From: Simon Davis
Sent: 19 June 2018 17:35
To: Planning Scanning
Subject: FW: The Coach House, Norton Lane AL/43/18/DOC

"Based on the fact that the winter groundwater monitoring was limited I would like to ensure that the base of the soakaway is set no lower than 1.2m deep. And a factor of safety of at least 1.5 (preferably 2) applied to the calculations, in line with CIRIA R156/ CIRIA C609. Based on my calculations this will likely require a slight increase in the tank area from 3m by 3.5m to 3m by 4m. Apart from this, I am happy with the details provided."

SITE PLAN 1:200 @ A3

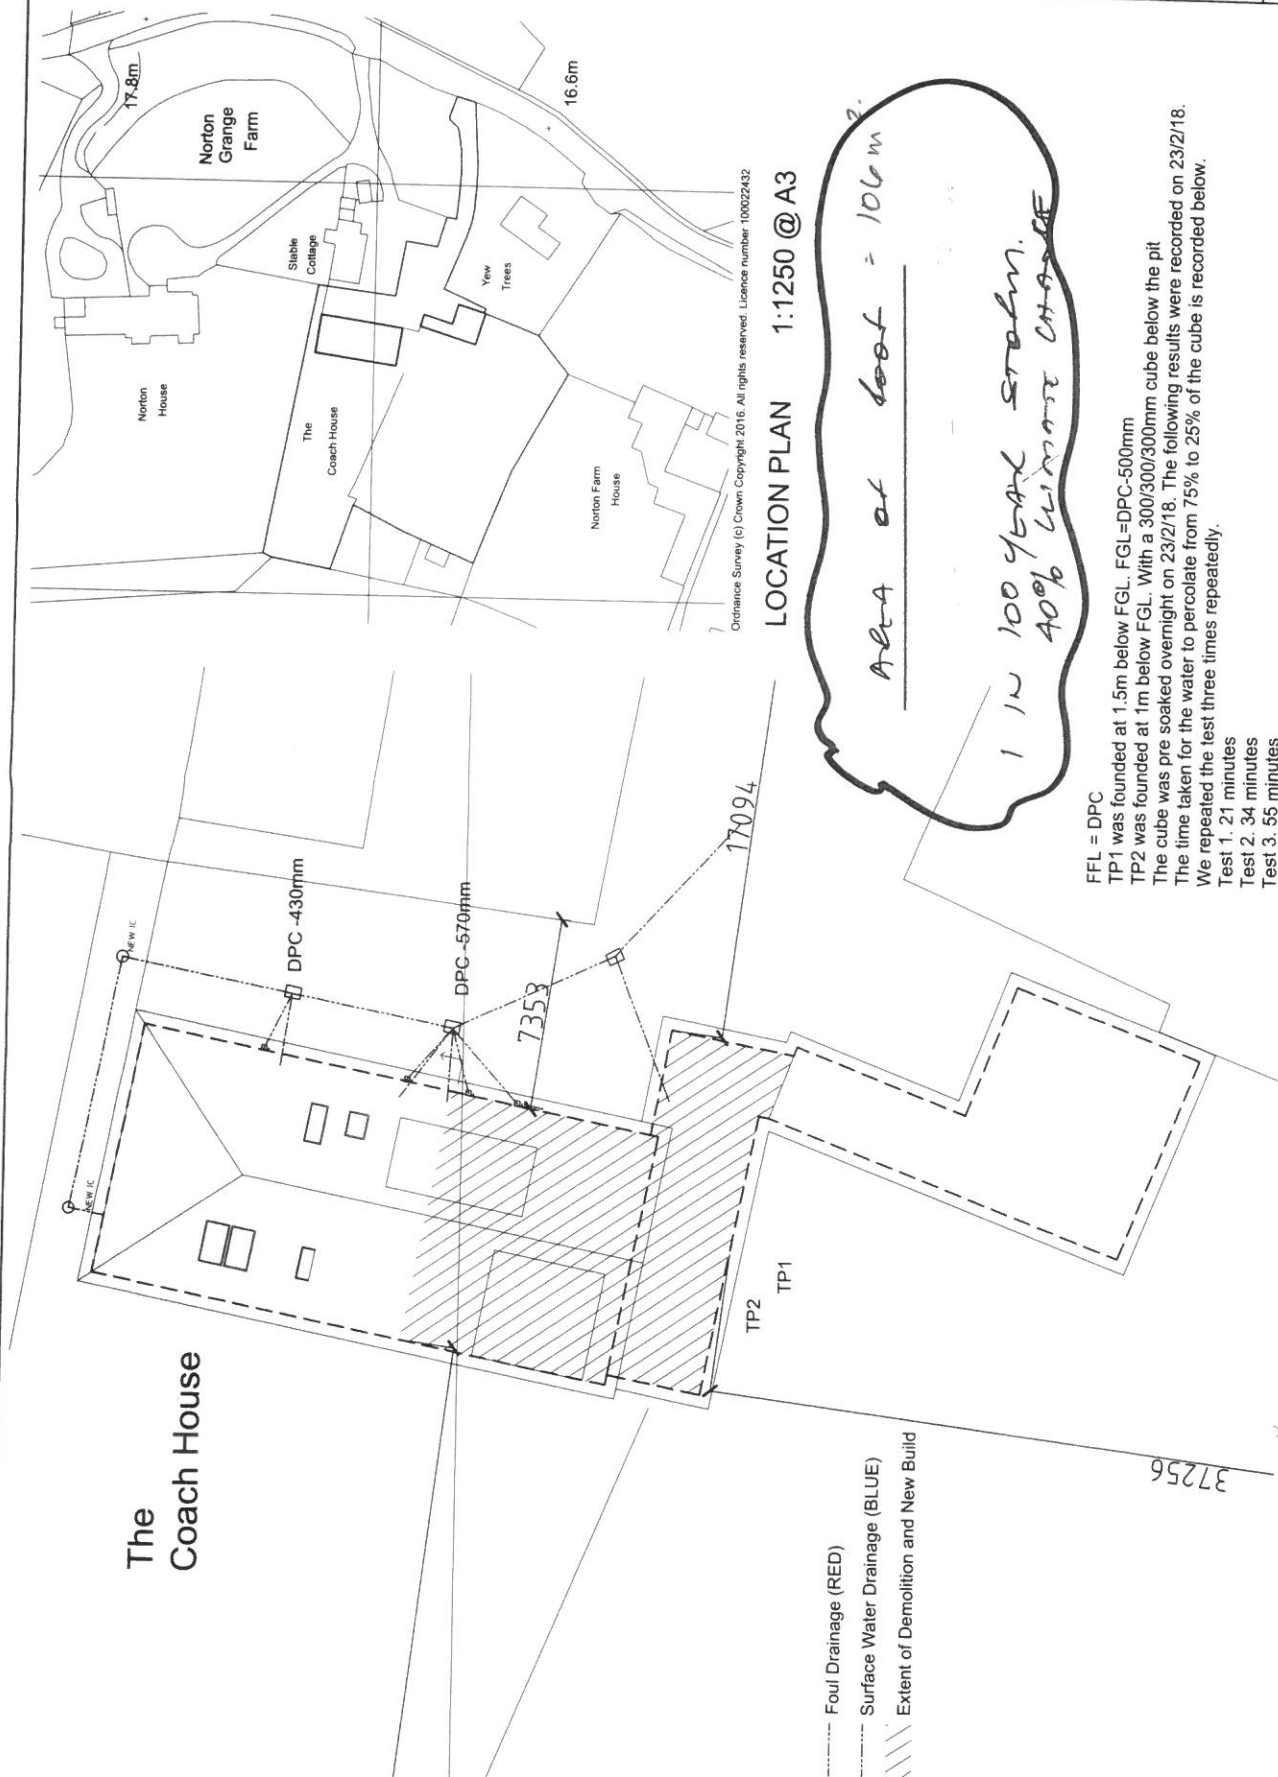
Can you please amend the submitted plans/details to reflect these and resubmit to me.
